Search application details

Application number: 2020/91474	
What is the application for?:	Formation of 55 space car park with associated works
Address of the site or building:	Former scrap yard, adj Canalside West, Firth Street, Huddersfield, HD1 3DB
Postcode:	HD1 3BL

User comments

Title
Proposed Plans

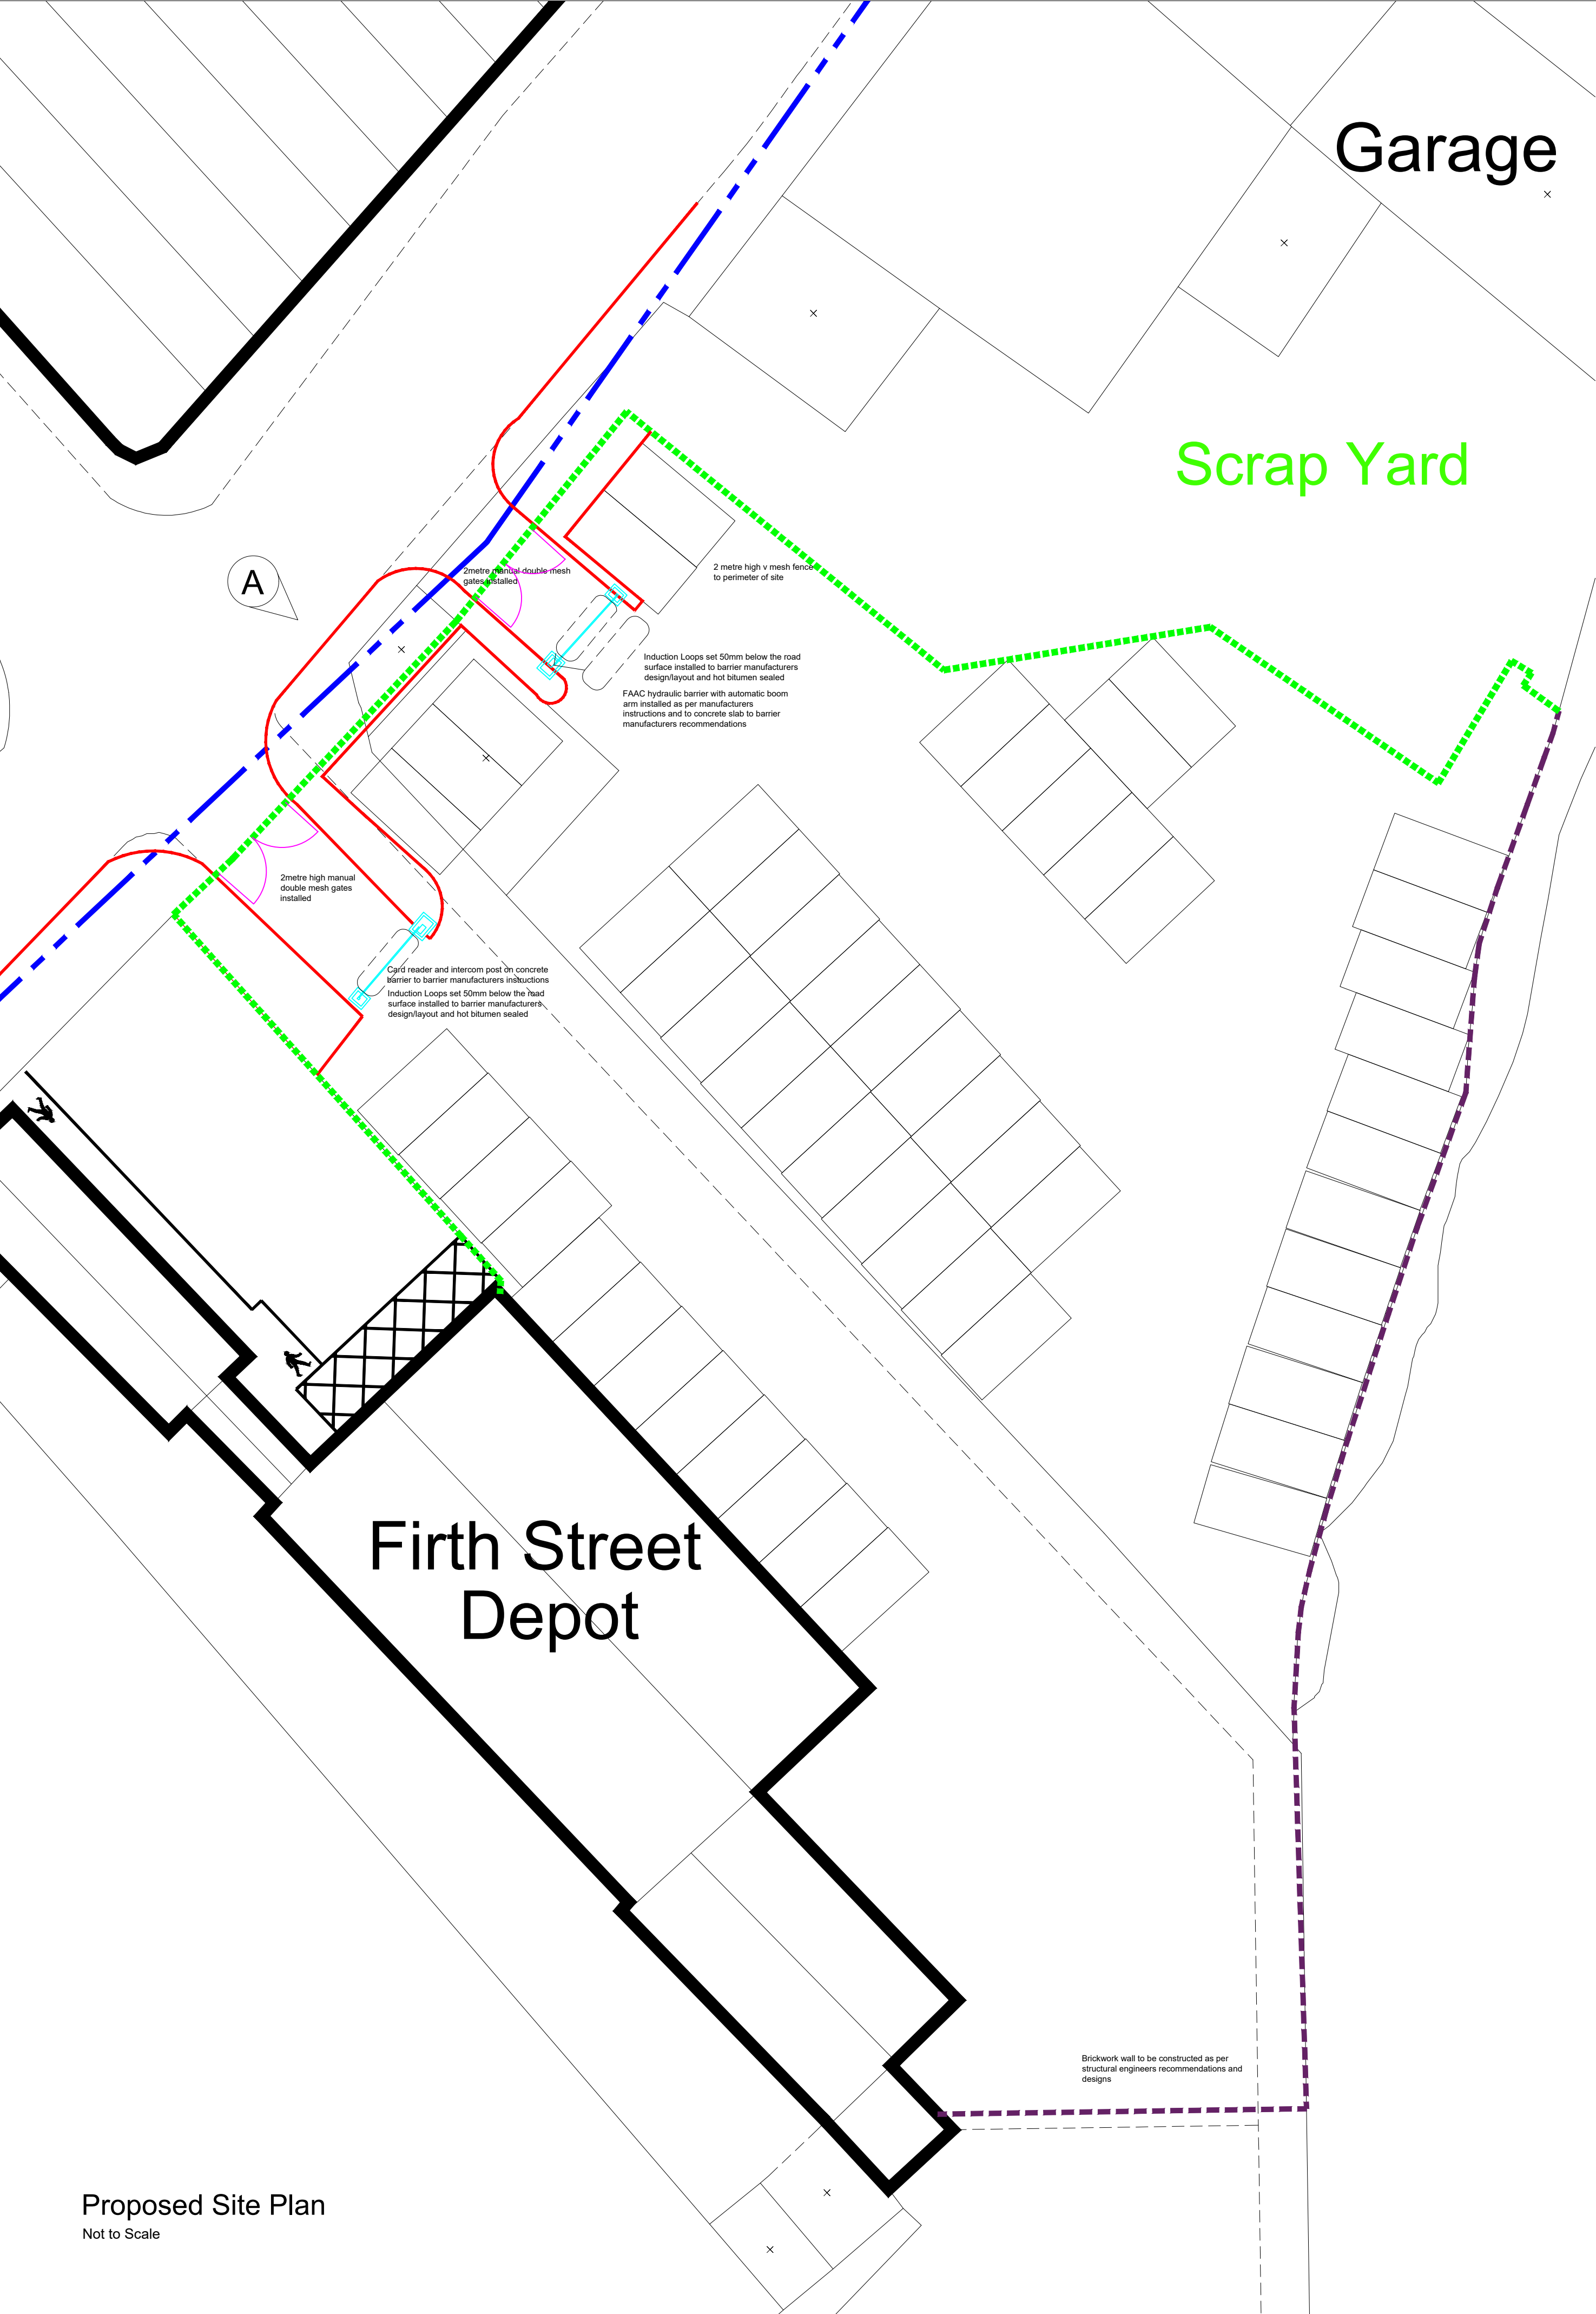
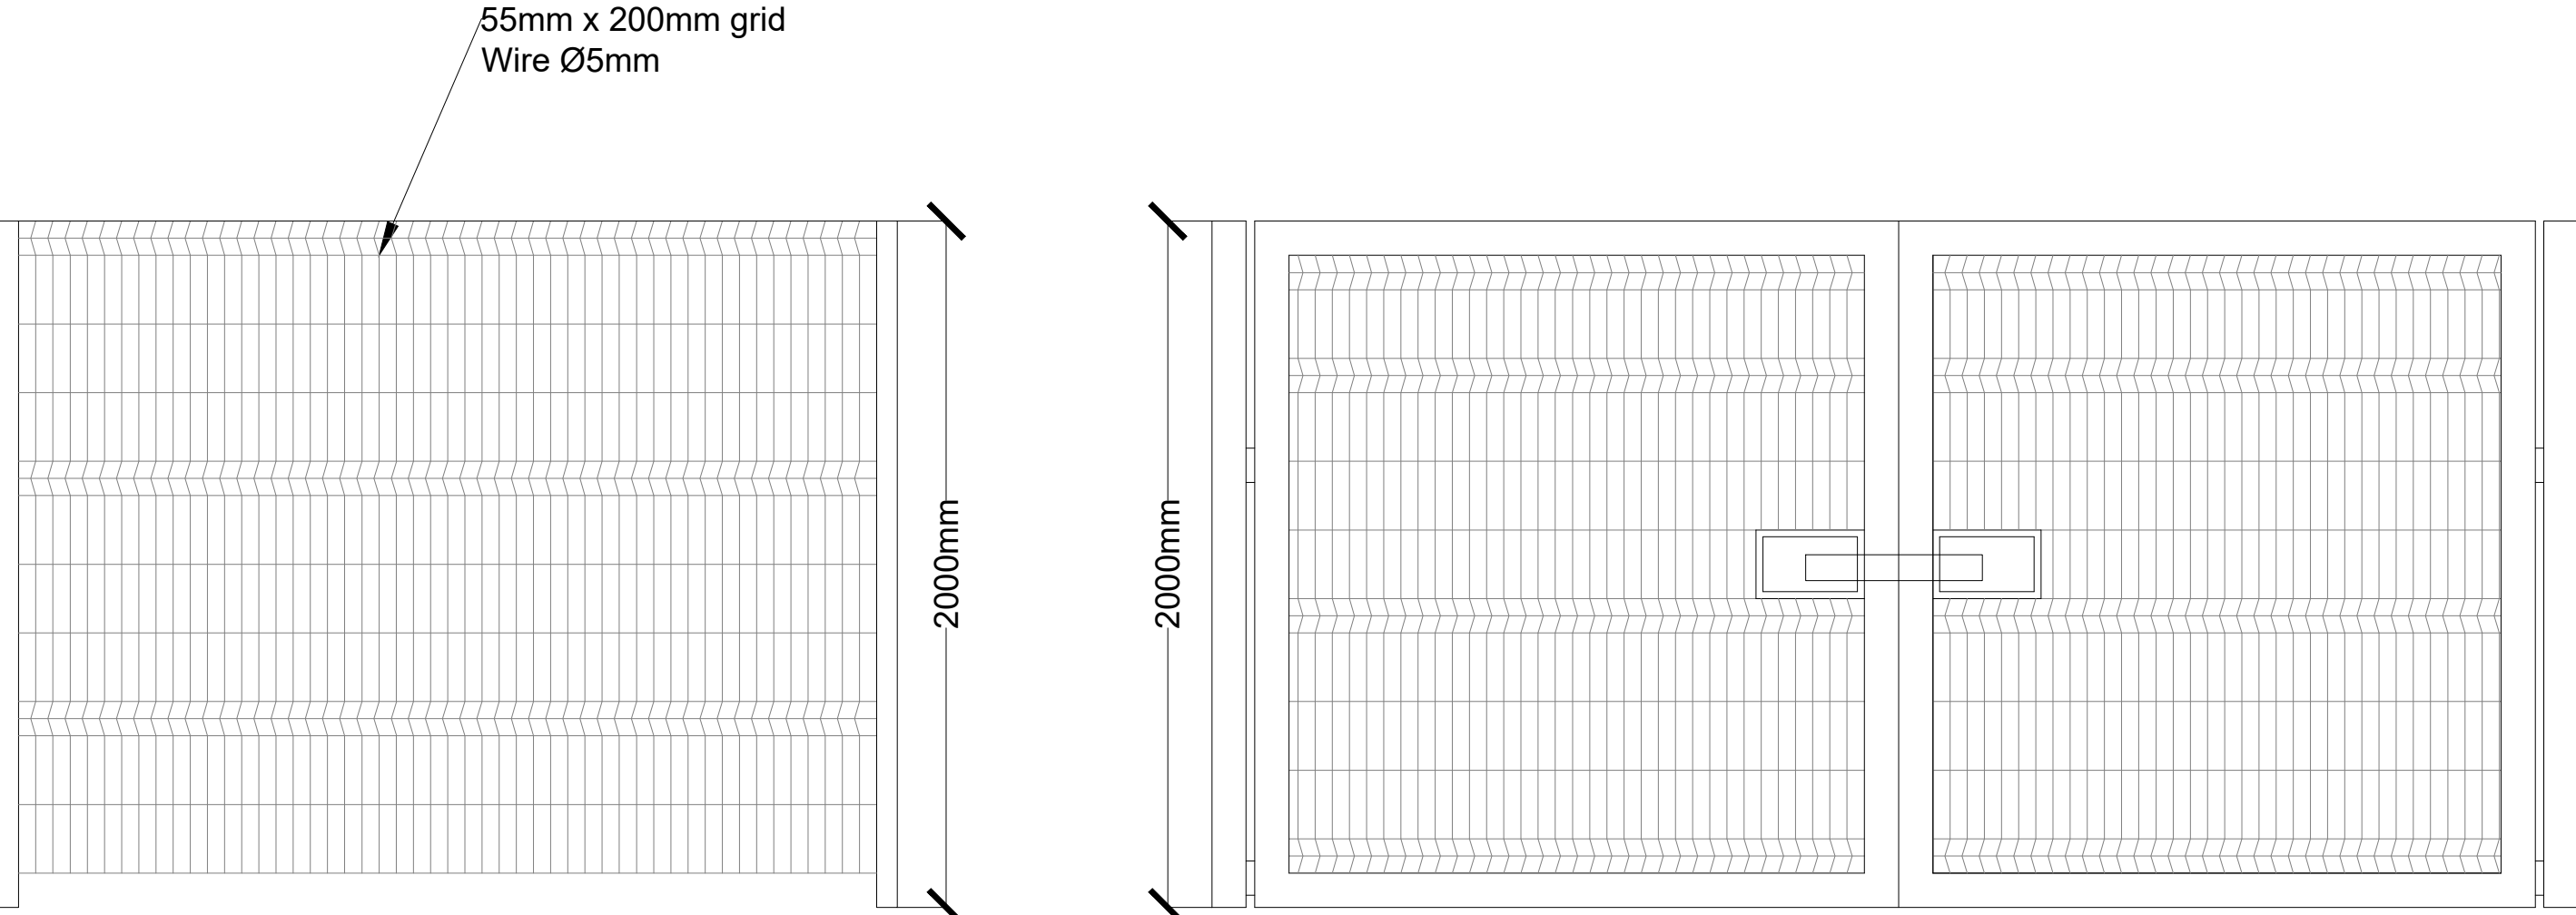
Type of comment: An objection
looking at the plans it would seem the proposed entrance/exit to the car park is very close to the main vehicle & pedestrian entrance to the adjoining business.vehicles are regularly using this entrance for loading & unloading if vehicles are parked in the gateway i believe it will be very difficult & dangerous for vehicles entering & exiting the car park.also the volume of pedestrians runs into the thousands during term time using the pavements where the entrance & exit are proposed mostly from surrounding student accomadation & car parks.
